WEST SUSSEX COUNTY COUNCIL CONSULTATION

TO:	Arun District Council FAO: Michael Eastham
FROM:	WSCC - Highways Authority: Tim Townsend
DATE:	9 November 2020
LOCATION:	Land south of Ford Lane East of North End Road Yapton BN18 0DS
SUBJECT:	Y/105/20/DOC Approval of details reserved by condition imposed under Y/80/16/OUT relating to condition 10- Construction Method Statement. More information received.
DATE OF SITE VISIT:	19 October 2020
RECOMMENDATION:	More Information Required
S106 CONTRIBUTION TOTAL:	£ See outline consent.

This is the third WSCC County Highway Authority (CHA) response to the above planning application for approval of details reserved by condition imposed under Y/80/16/OUT relating to condition 10 - Construction Method Statement (CMP). Previous CHA comments were made in response dated 19th October 2020 and 29 October 2020 and this response should be read alongside those.

Scale 1:200 @A1	Date AUG 20	Designed
Drawn JA	Checked SG	Approved LH
Job No 18-344	Drawing No 18-344/703	Rev B

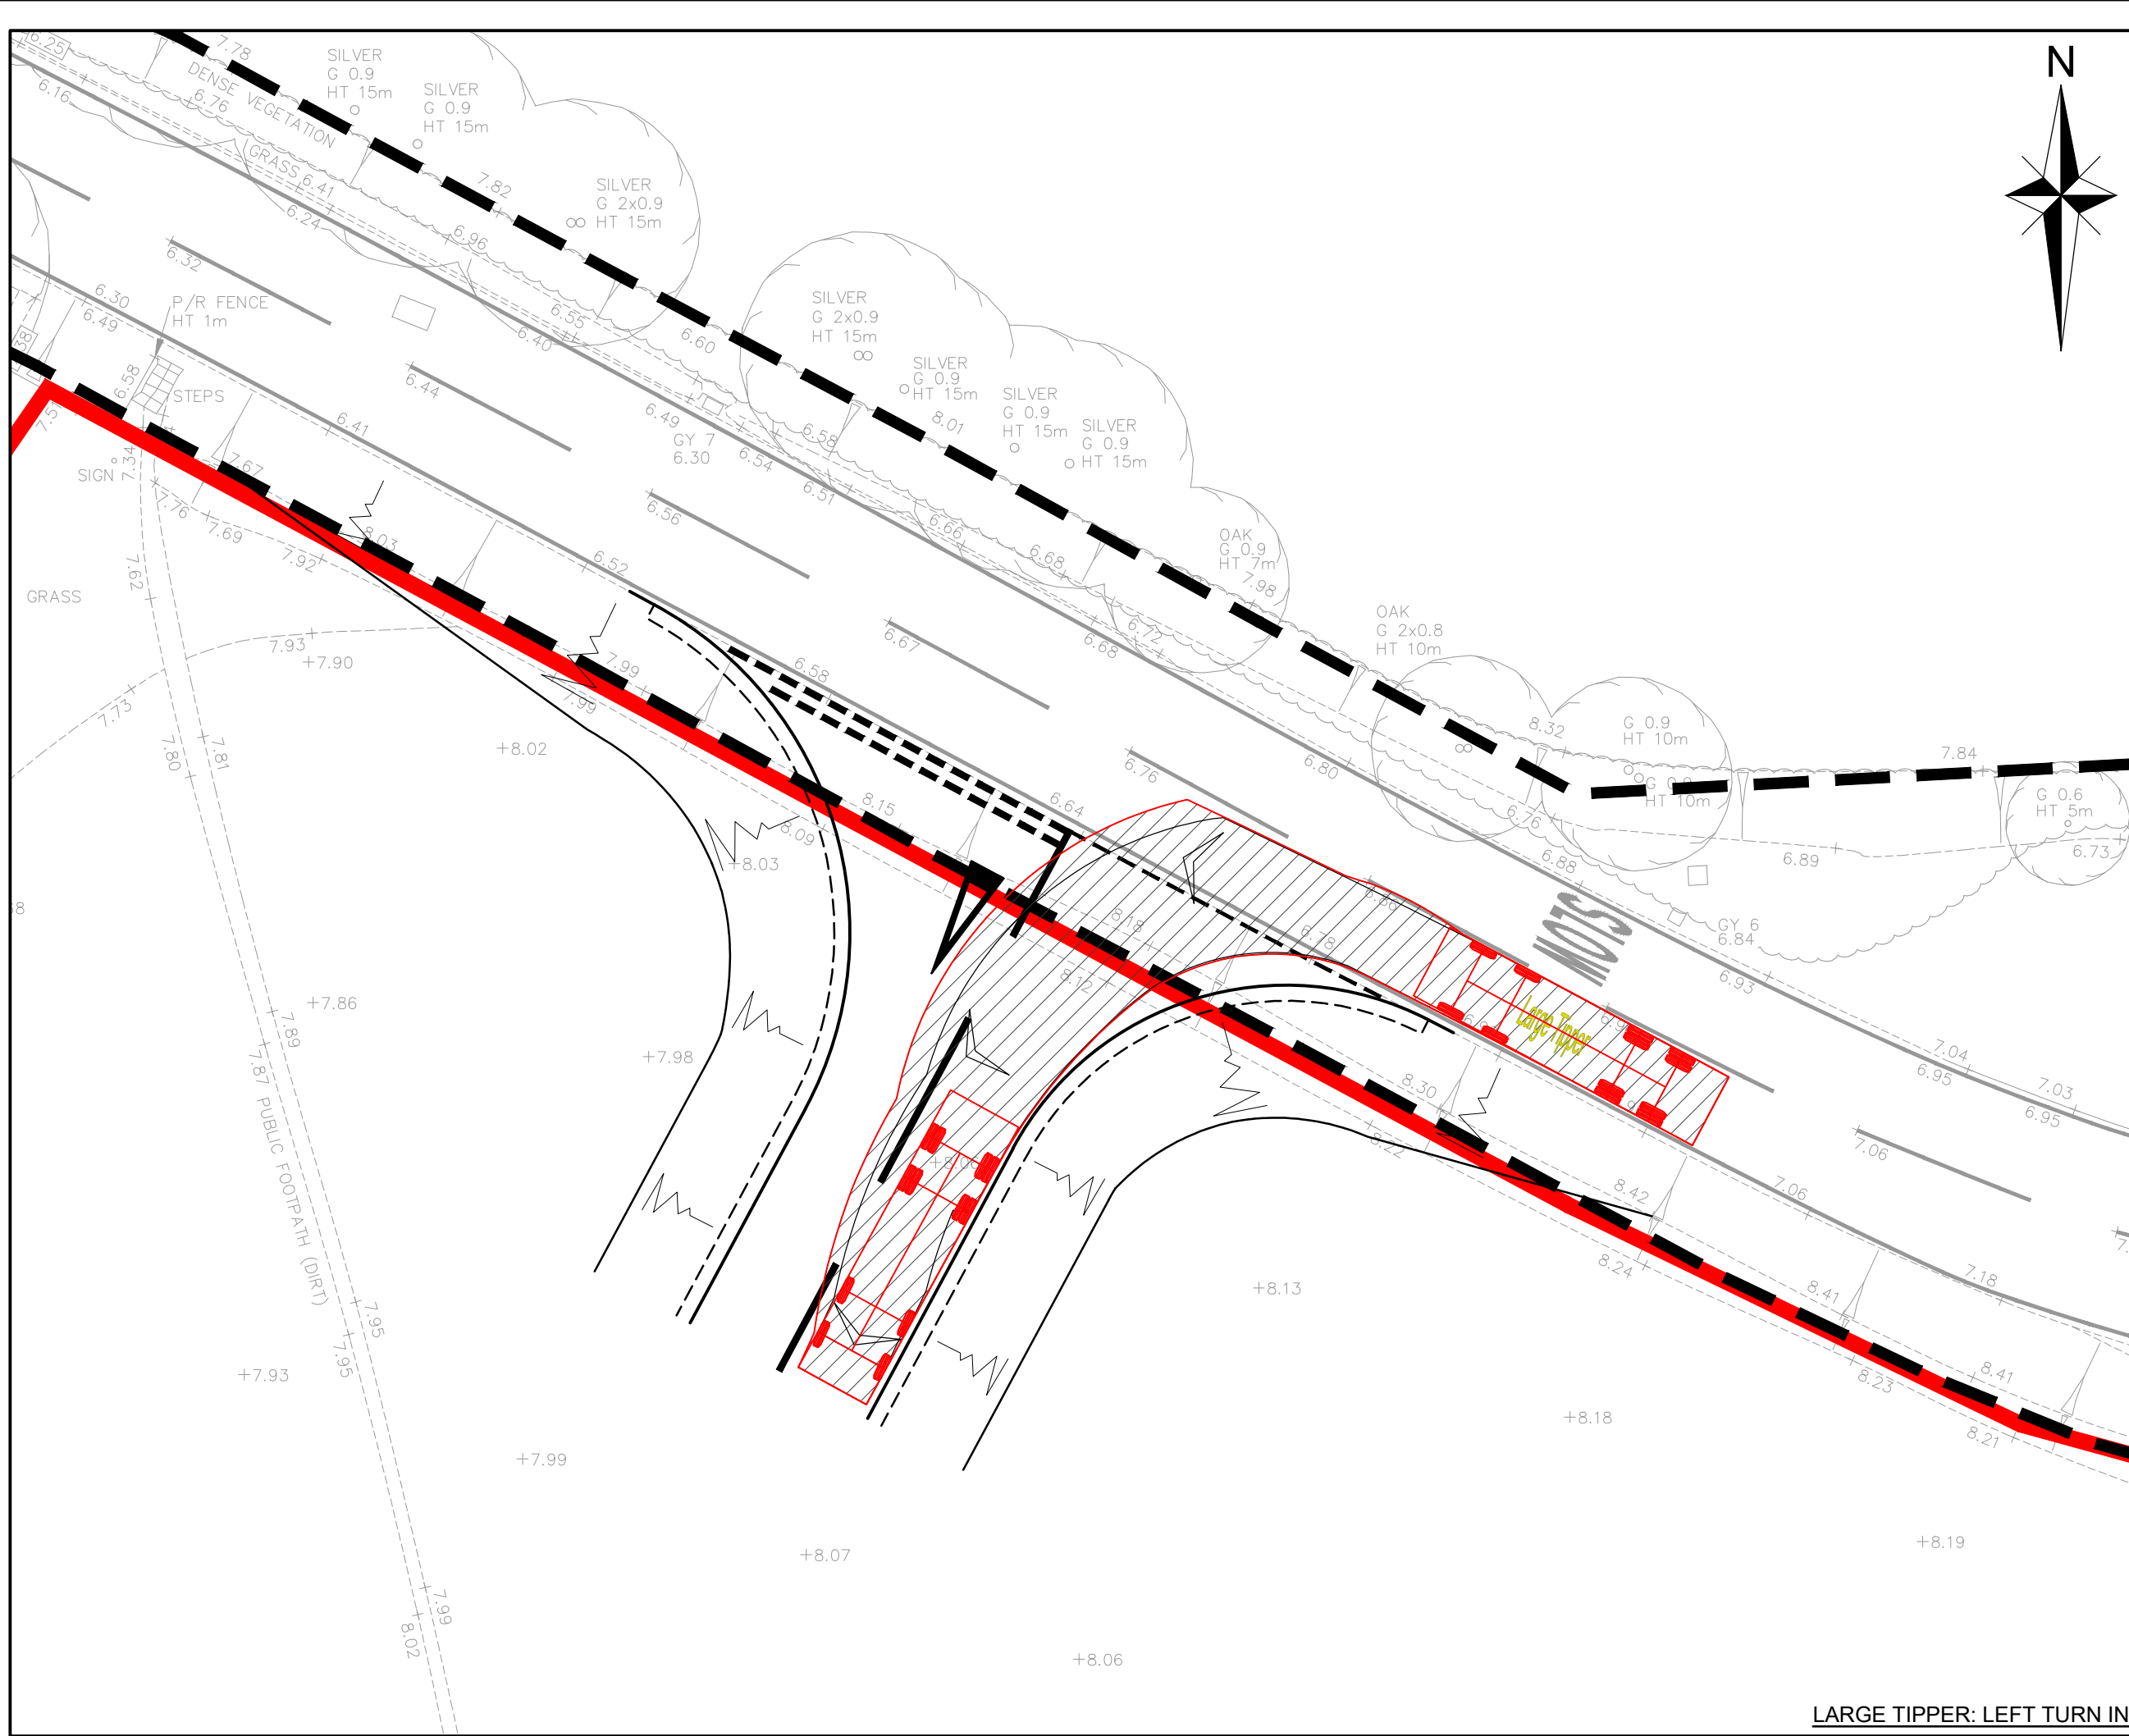
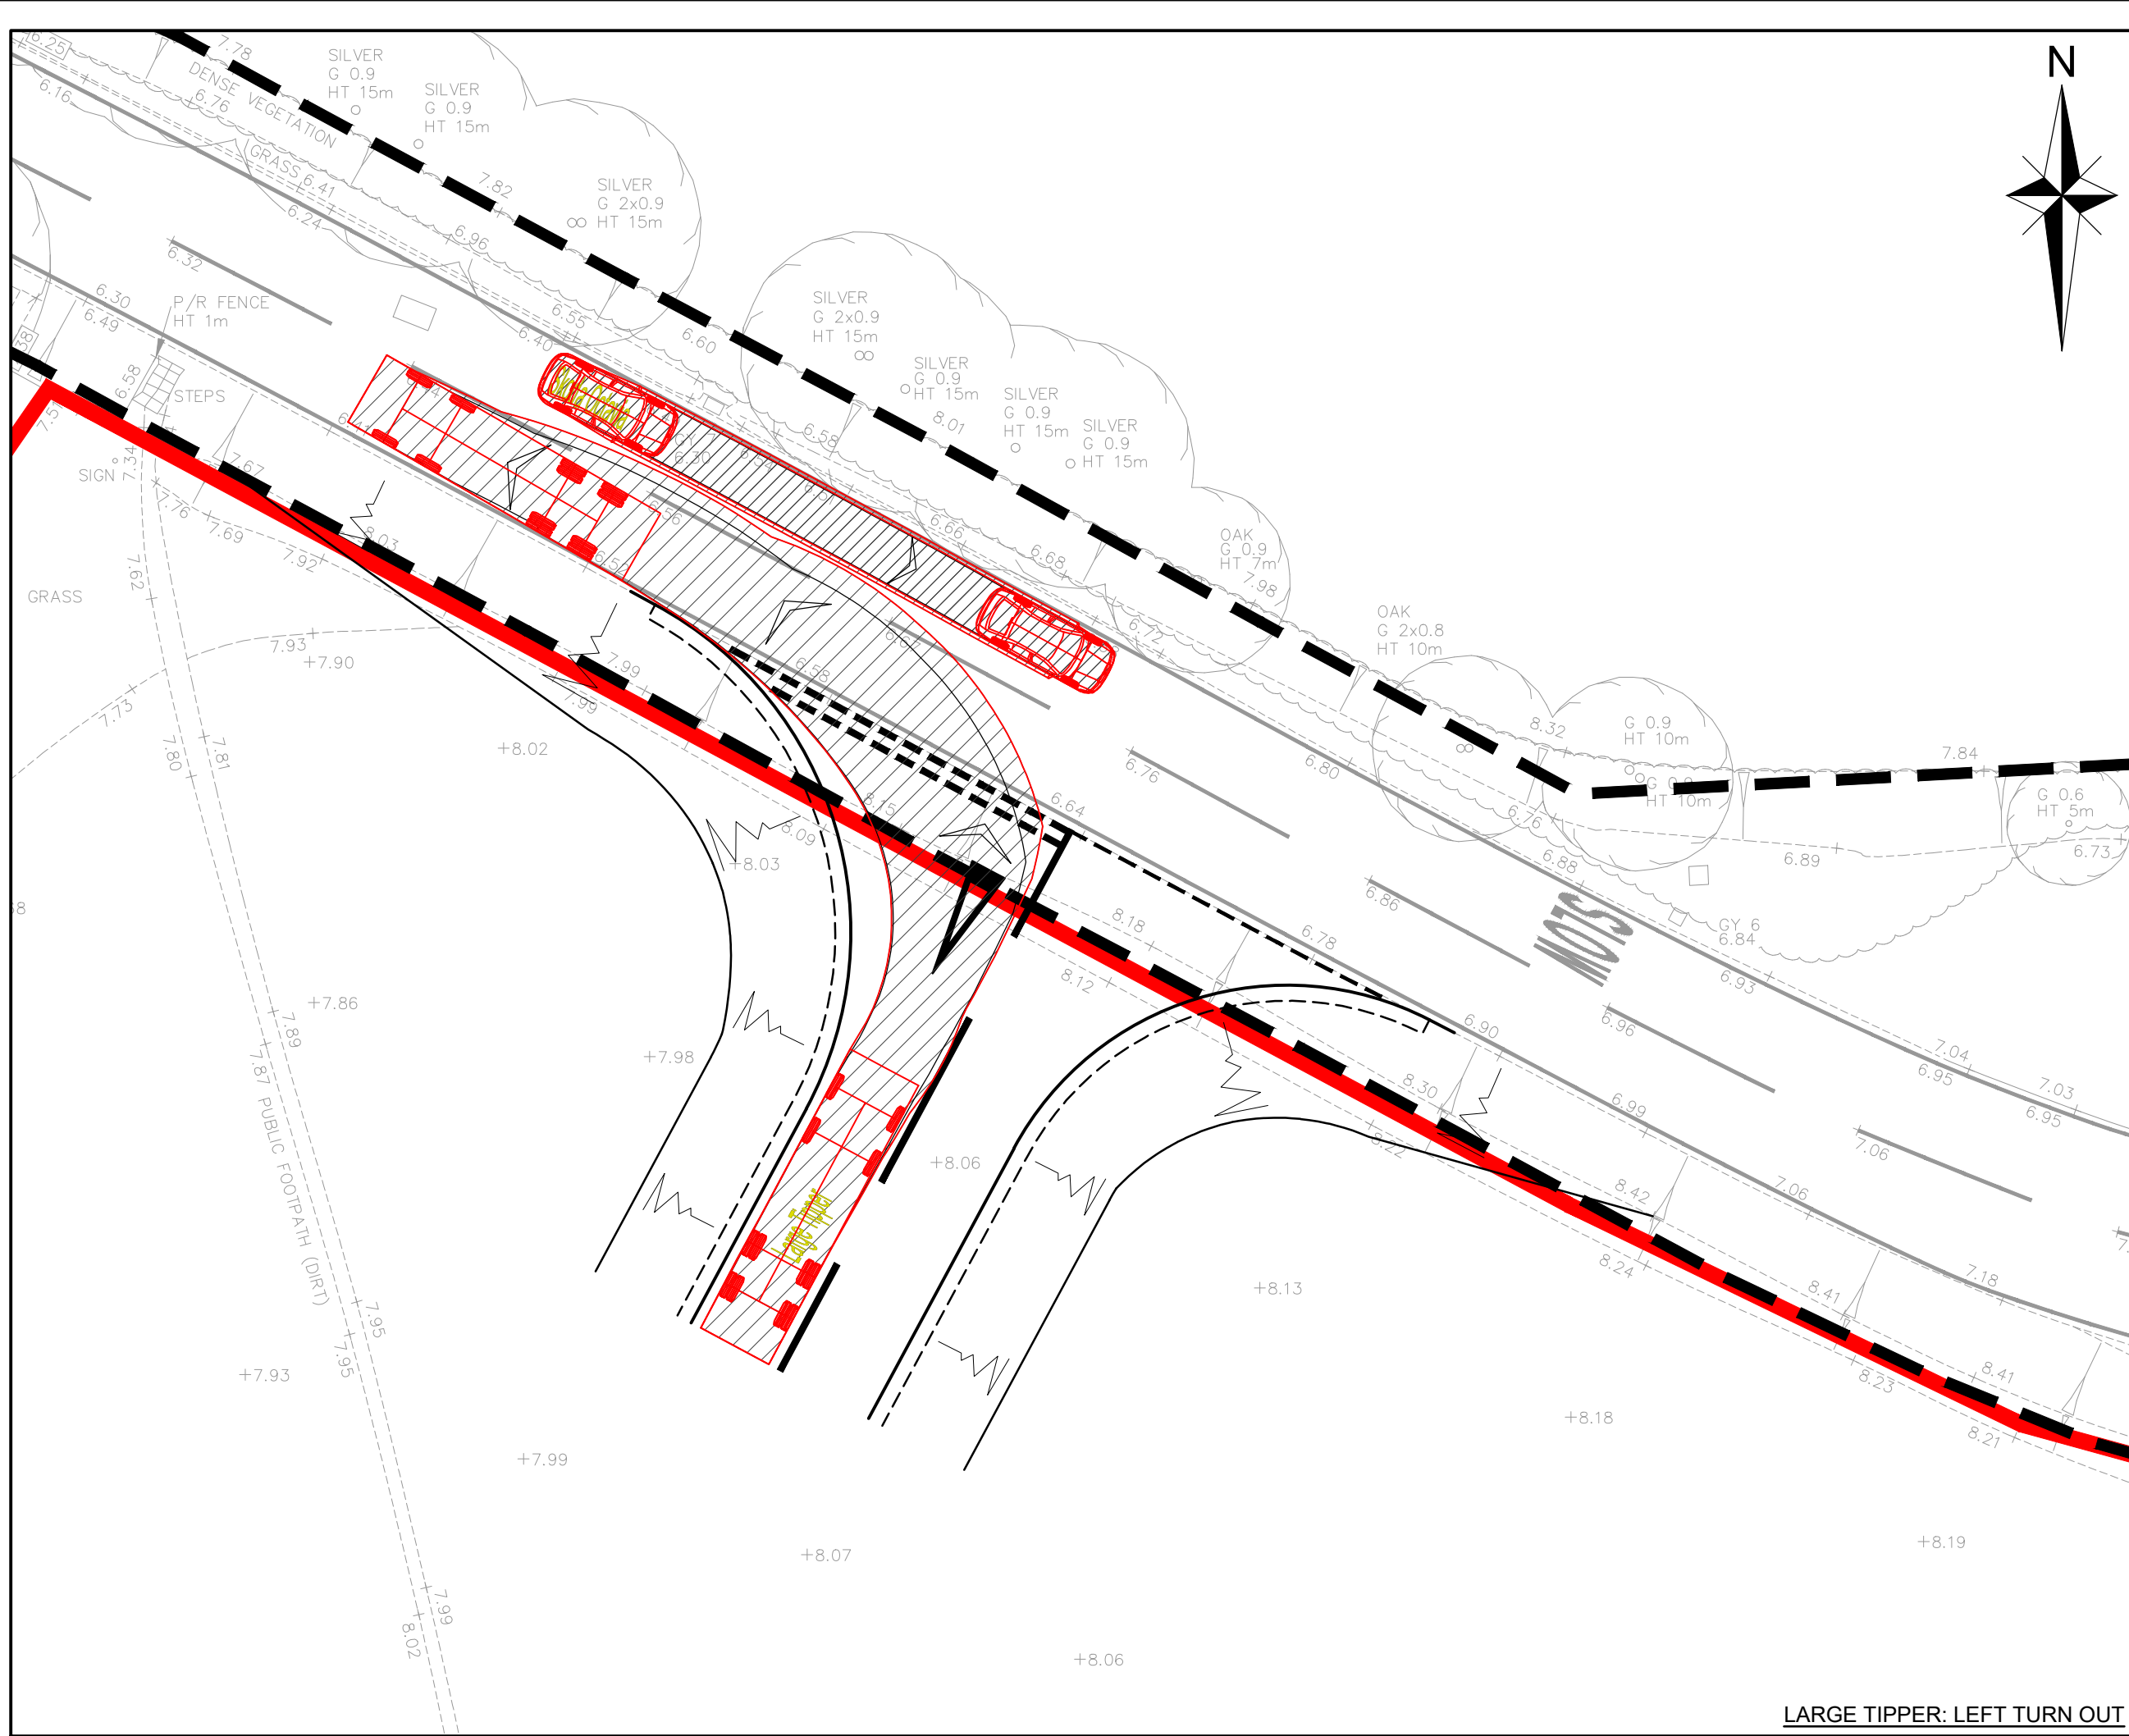
- ***‘Problem’ 3.3.1 – Risk of insufficient visibility which could lead to rear end shunt and/or side impact collisions*** – The designer’s response is not accepted by the CHA. As per the recommendation in the Safety Audit, adequate visibility is required for this access (both site access and forward visibility). Reference is still made to speed surveys taken circa 2014 (assumed to be for the main site access and NOT this temporary access), whereas a further survey has been undertaken and is

not referenced. However, consideration of the results of this latter survey do not appear to show the correct 85th percentile results (the ones listed appear too low). As such, the designer should provide further information in support of those + calculations. Visibility splays (including forward visibility splays) should then be shown on a revised plan in accordance with the results of the survey.
